CITY OF ALBUQUERQUE

June 28, 2024

Re: Hotel at Winrock Town Center
2100 Louisiana Blvd. NE
90-Day Temporary Certificate of Occupancy
Transportation Development Final Inspection
Architect's Stamp dated 07-21-21 (J19-D058I)
Certification dated 06-26-24

PROJECT TITLE WINROCK TOWN CENTER 2000 LOUISIANA BLVD NE ALBUQUERQUE, NEW MEXICO		DRAWN BY: XXX	
PROJECT MANAGER STEPHEN DINBAR, AIA		JOB NO. WIN-HOTEL	
SHEET TITLE PROPOSED HOTEL DEVELOPMENT		DATE: 1/11/21	
SCALE: RE: SCALE		SHEET NO. SP-1A2

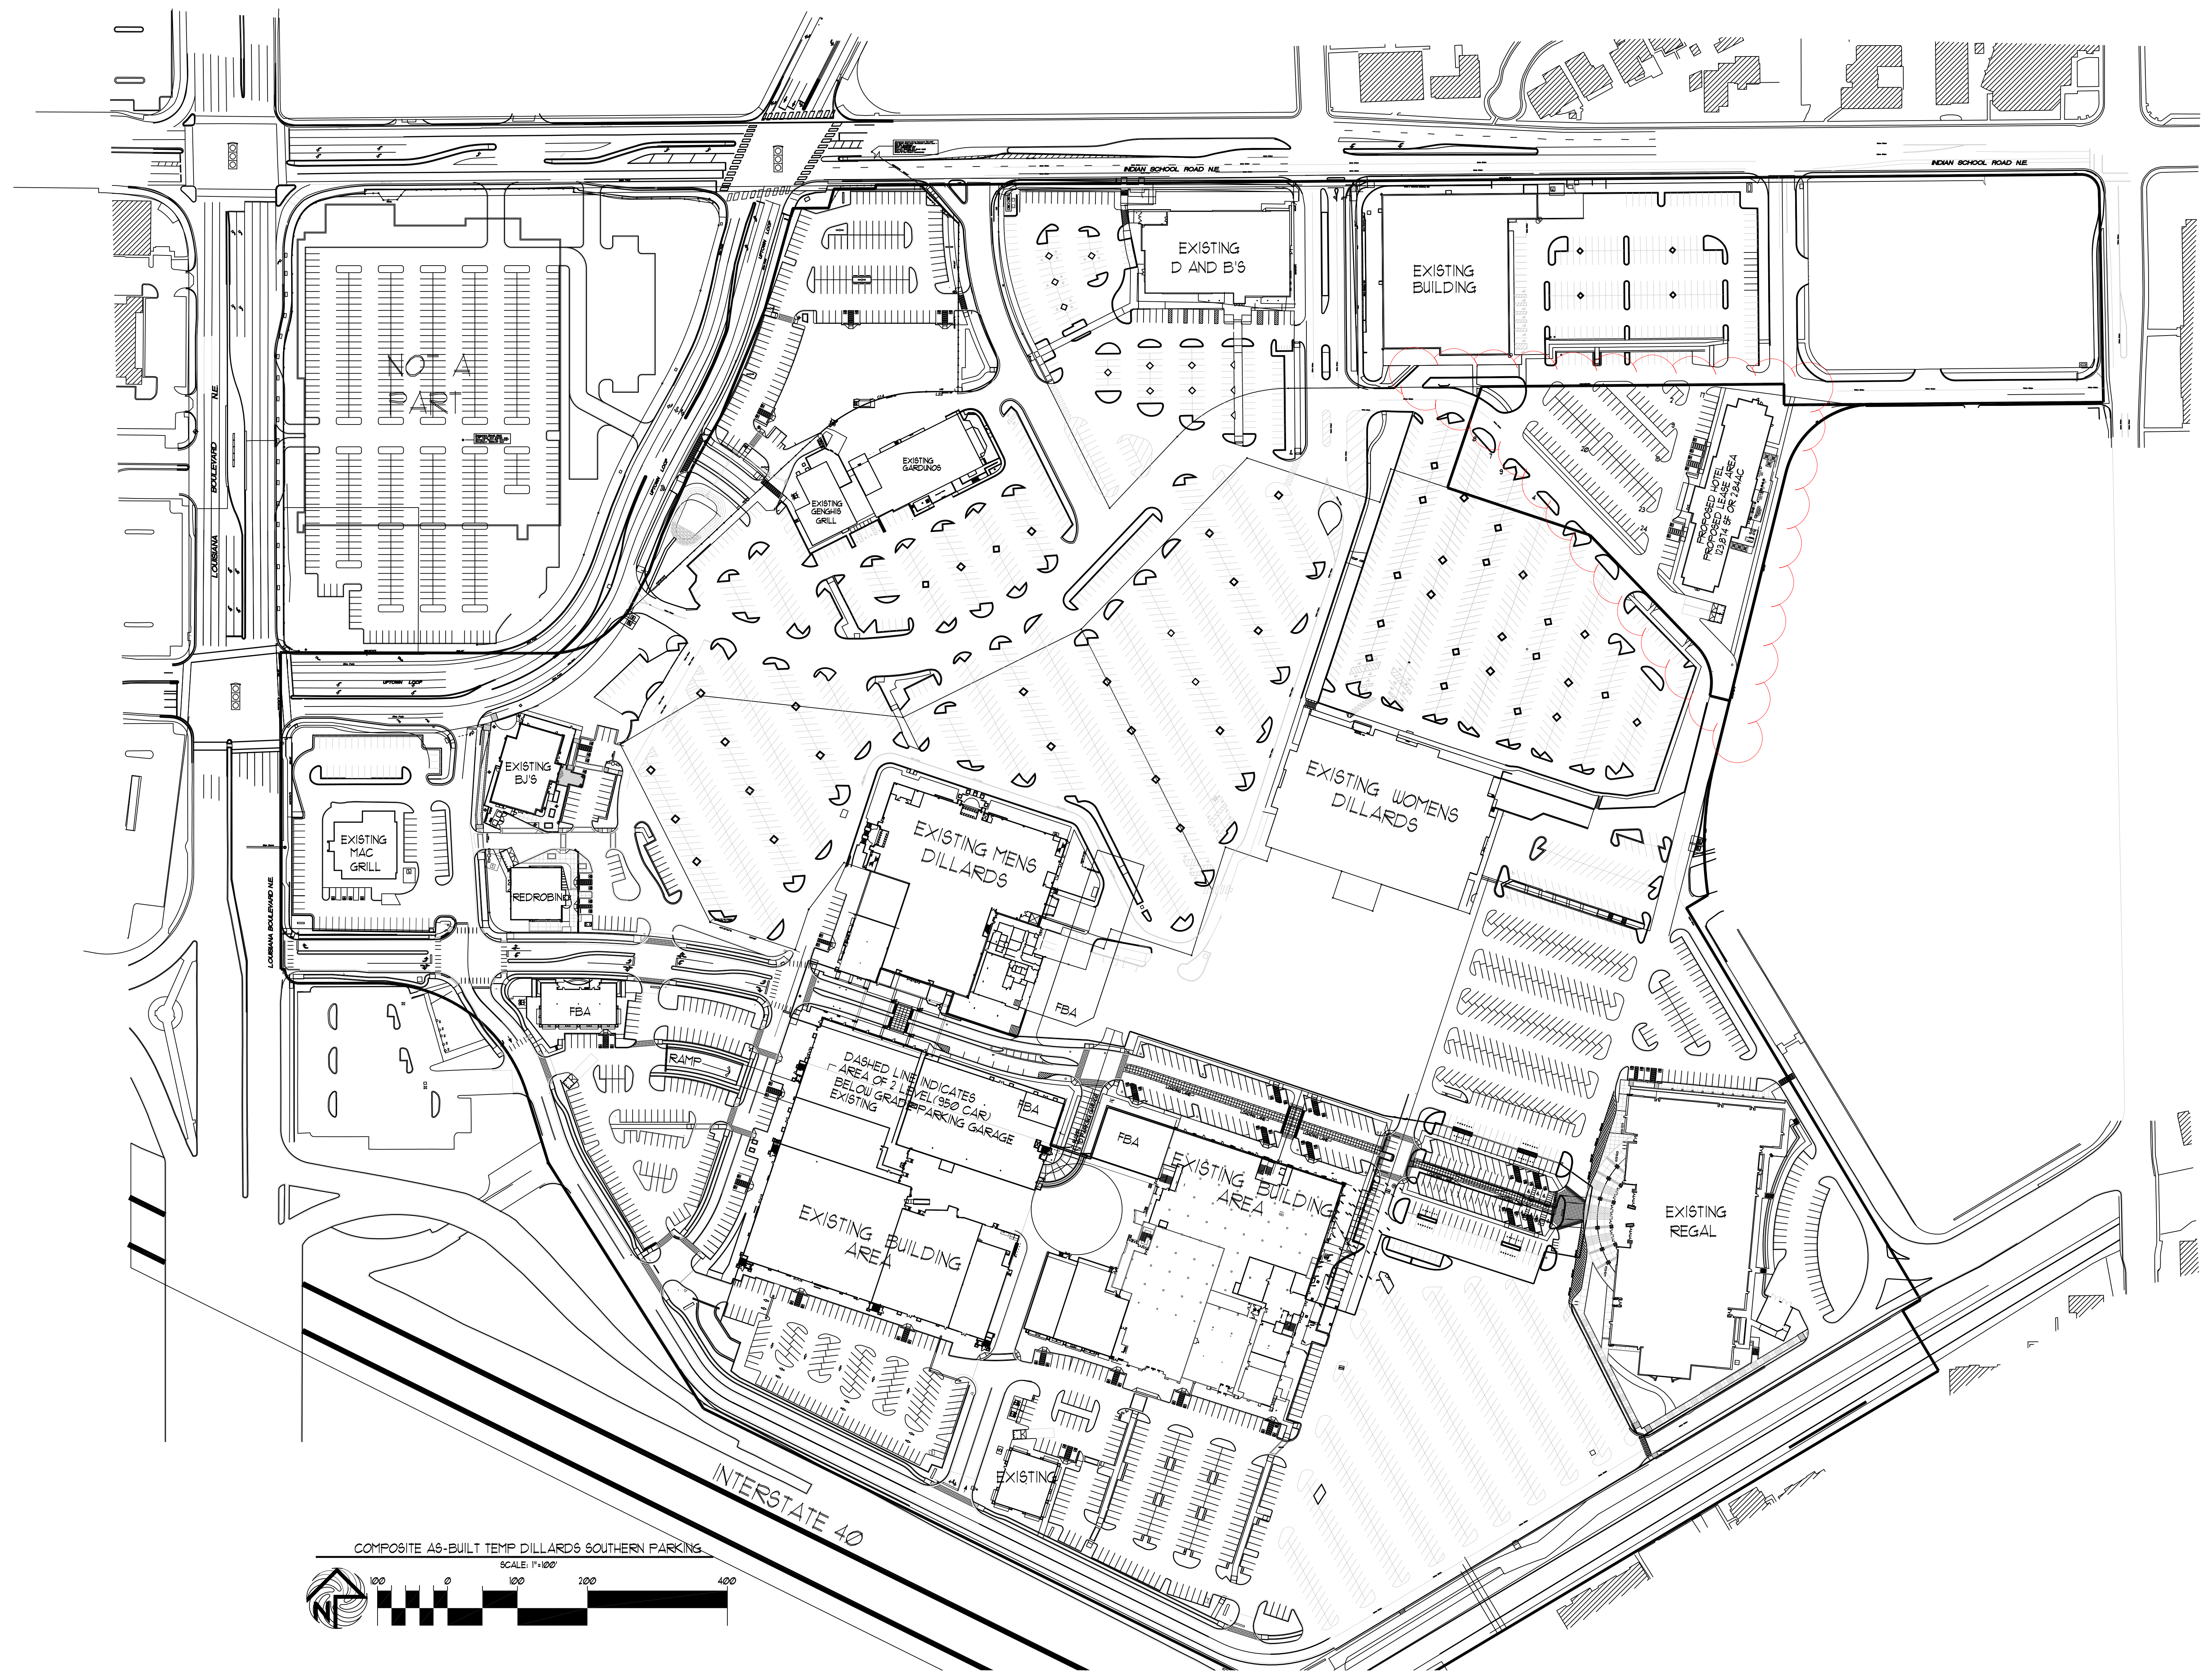
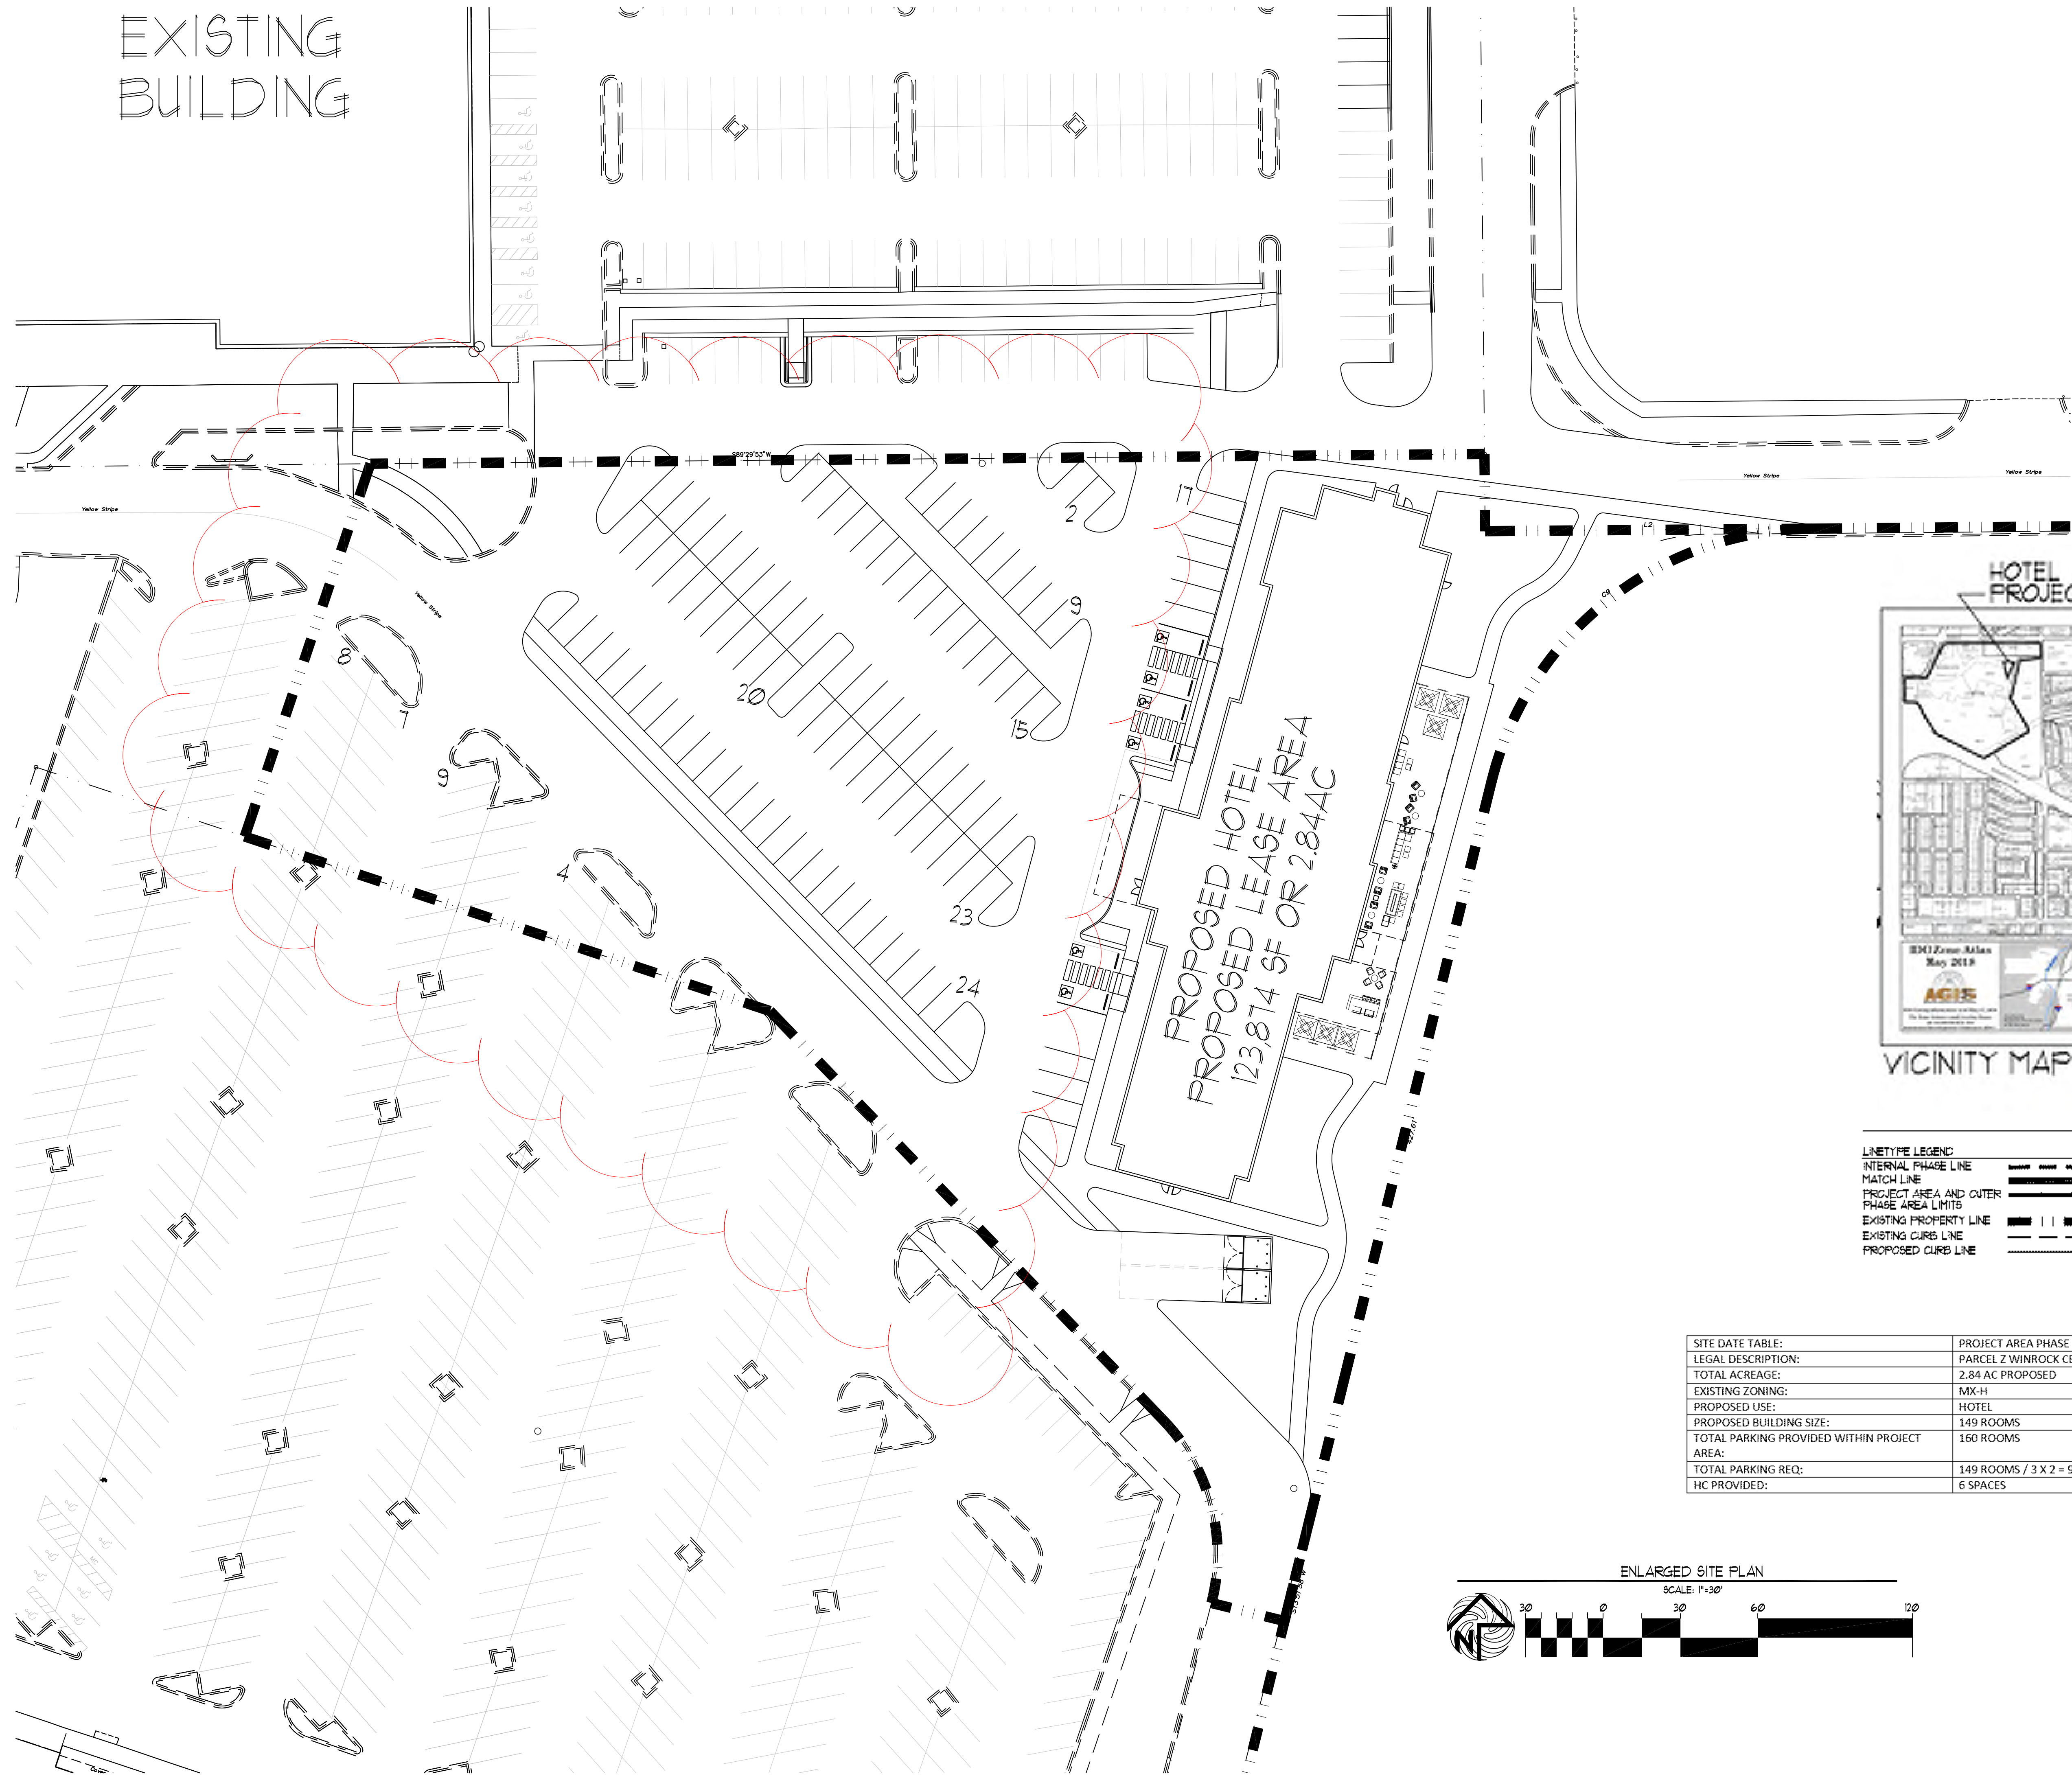
- Per the site visit: the running slope for the ADA ramp (keynote 15) at the southwest side of the building was ranged between 9-10%. The running slope for the ADA ramp at the south side of the site was ranged between 12-13%. And the running slope for the ADA ramp at the northwest side of the site ranged between 11-12%. Please reconstruct these ramps as the maximum running slope for the ADA ramps should be 8.2%.

- The ADA ramp at the northeast side of the building must be constructed per the approved plan.

- Anchor down the Bike Rack.
